**Consultation Response from KC,  
Lead Local Flood Authority**
**2026/91494 Land off, Penistone Road, Birdsedge, Huddersfield, HD8 8XP**
**Outline application for erection of residential development, including associated infrastructure works. All matters reserved except means of access into (but not within) the site from Penistone Road.**
**Date Responded: 13/07/2026**
**Responding Officer: Martin Stephenson**
**Responding Ref: 1**
**Documents reviewed by the LLFA:**

- 300655, FRA and Drainage Statement, Rev 2, dated April 2026

**Drainage Summary:**

Appendix I
Drainage Layout Drawing

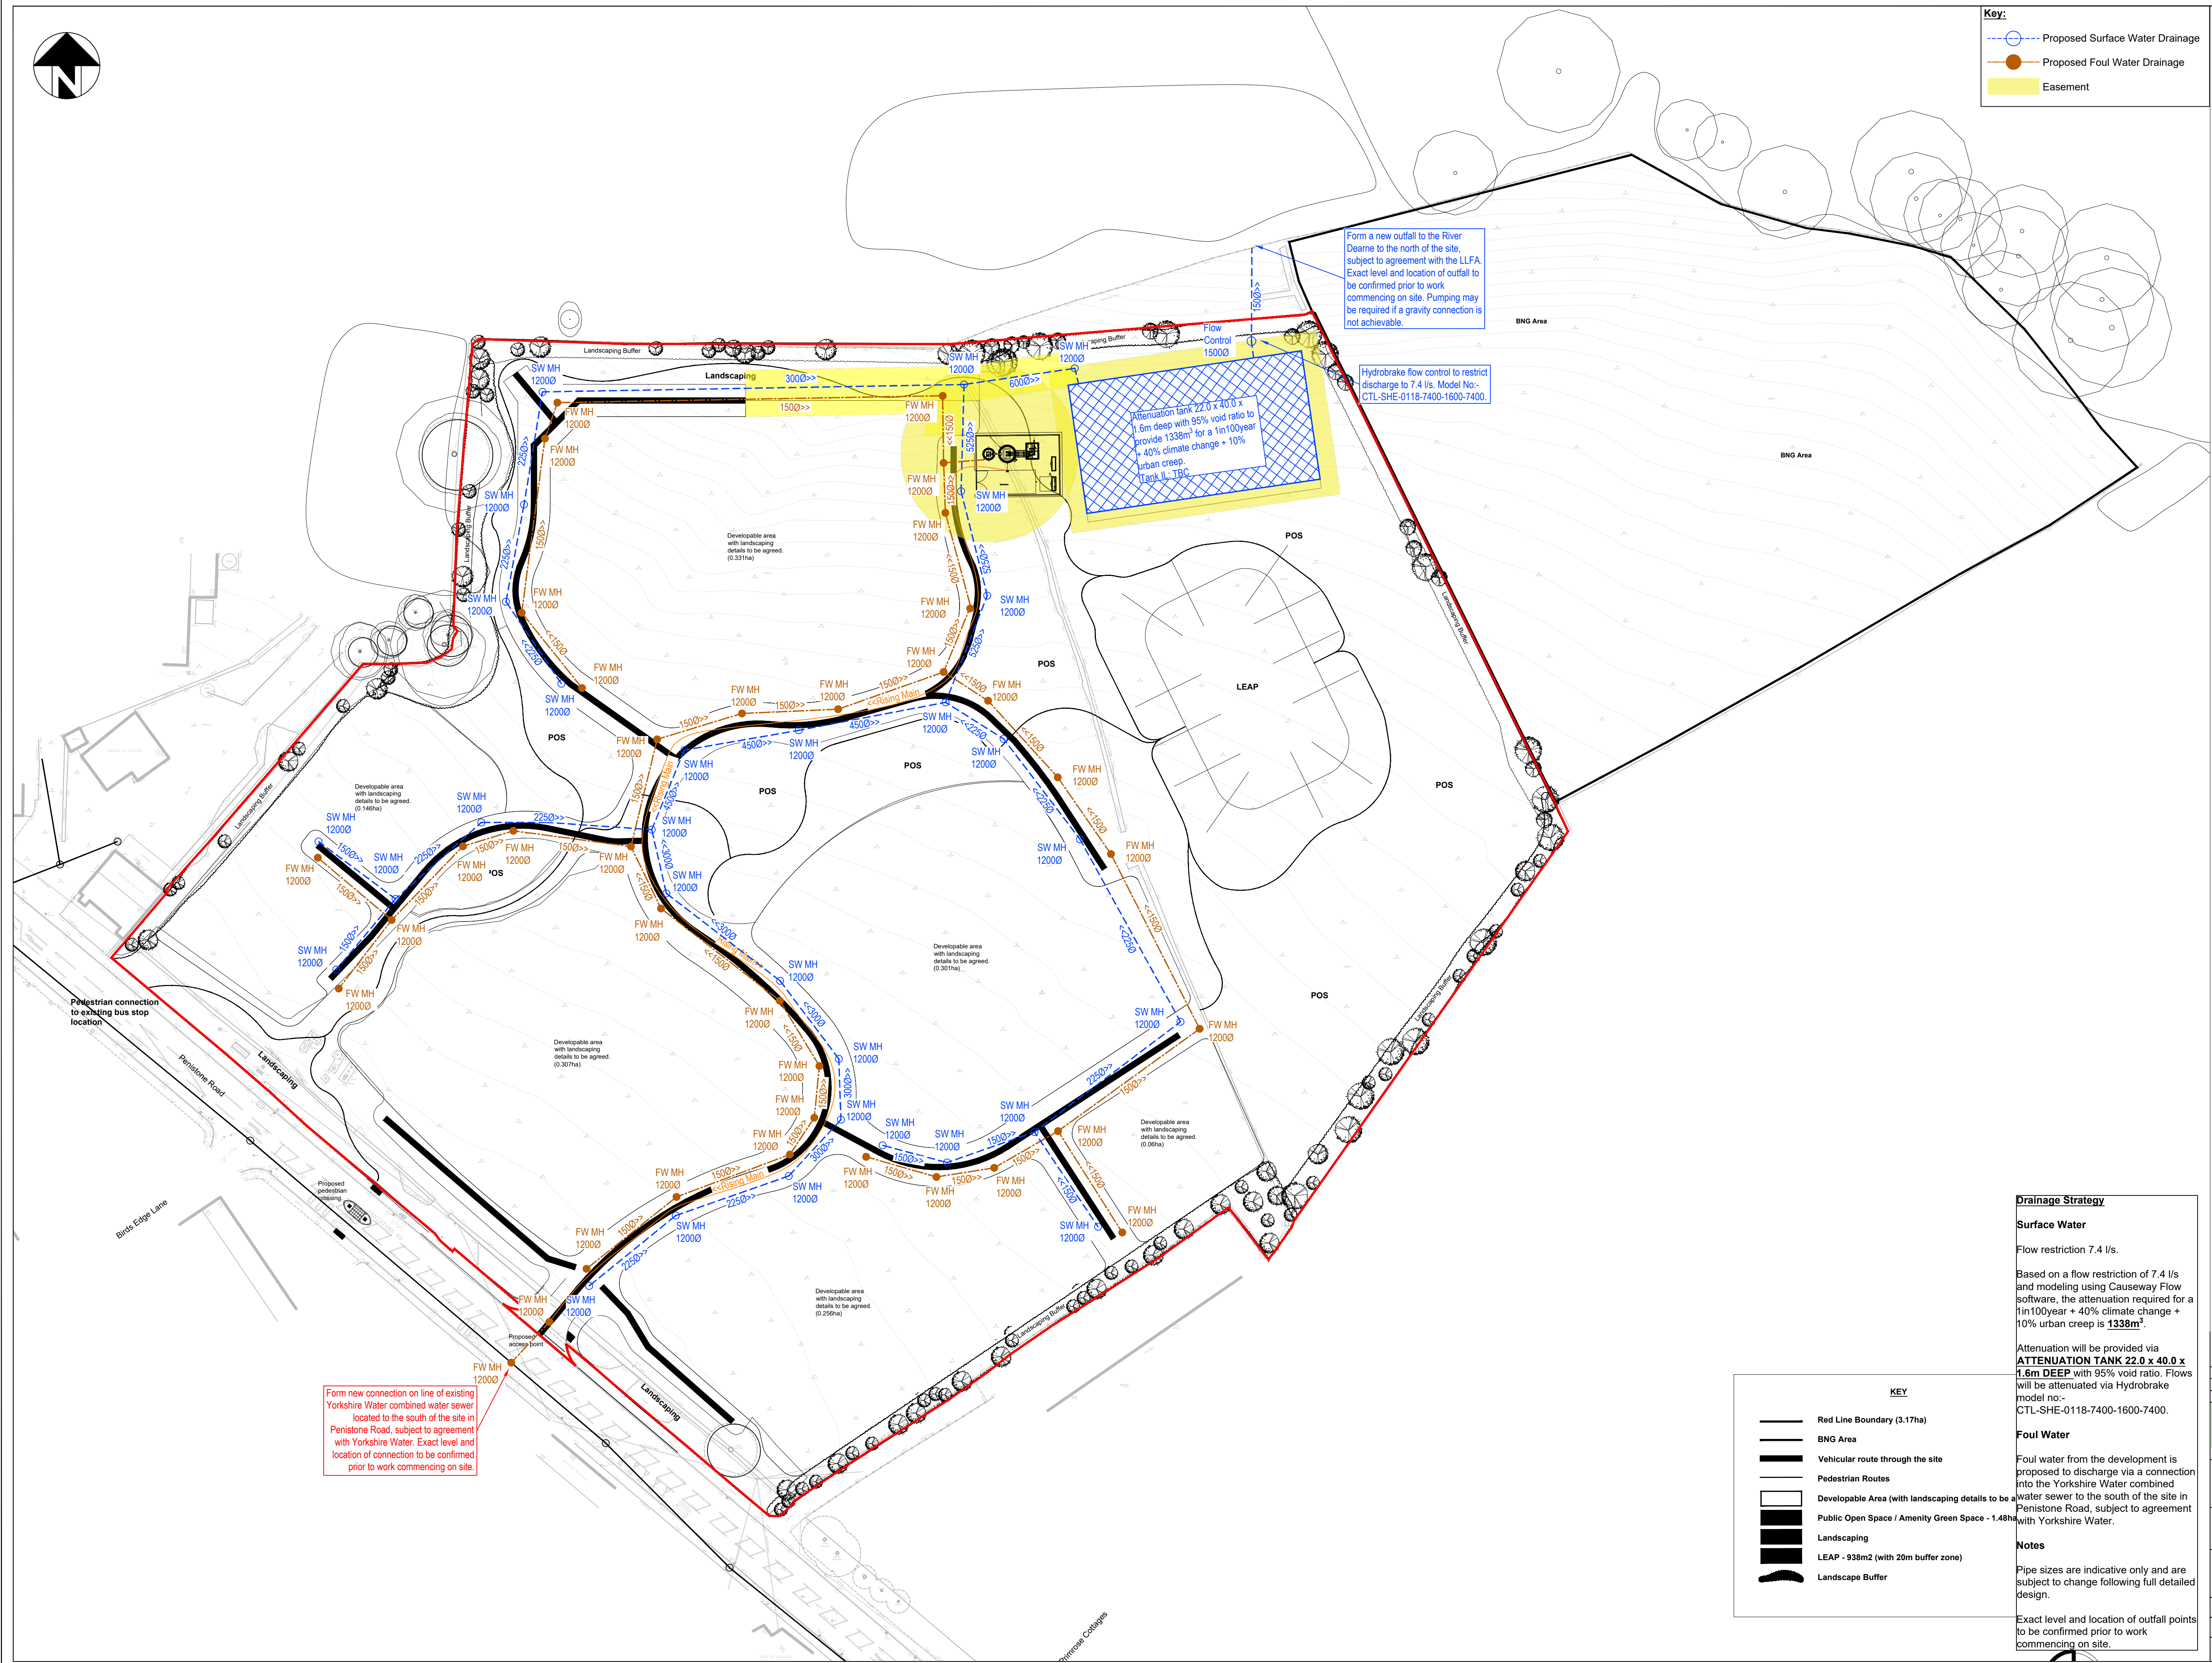
On developments of this size, the LLFA would expect that the attenuation tank would be of the “Carlow” concrete tank type instead of the proposed GeoCell type indicated on the Drainage Layout Drawing contained in Appendix I. If the developer wishes to use the GeoCell type, provisions will need to be made for its replacement at the end of its design life (typically 30 – 50 years).

Note that vehicular access to the tank and flow control chamber will be required to ensure inspection and maintenance operations can be easily undertaken and details provided of access into tank for inspection. It is also preferable that the upstream MH before the tank is of the catch-pit type to reduce the risk of siltation within the tank.
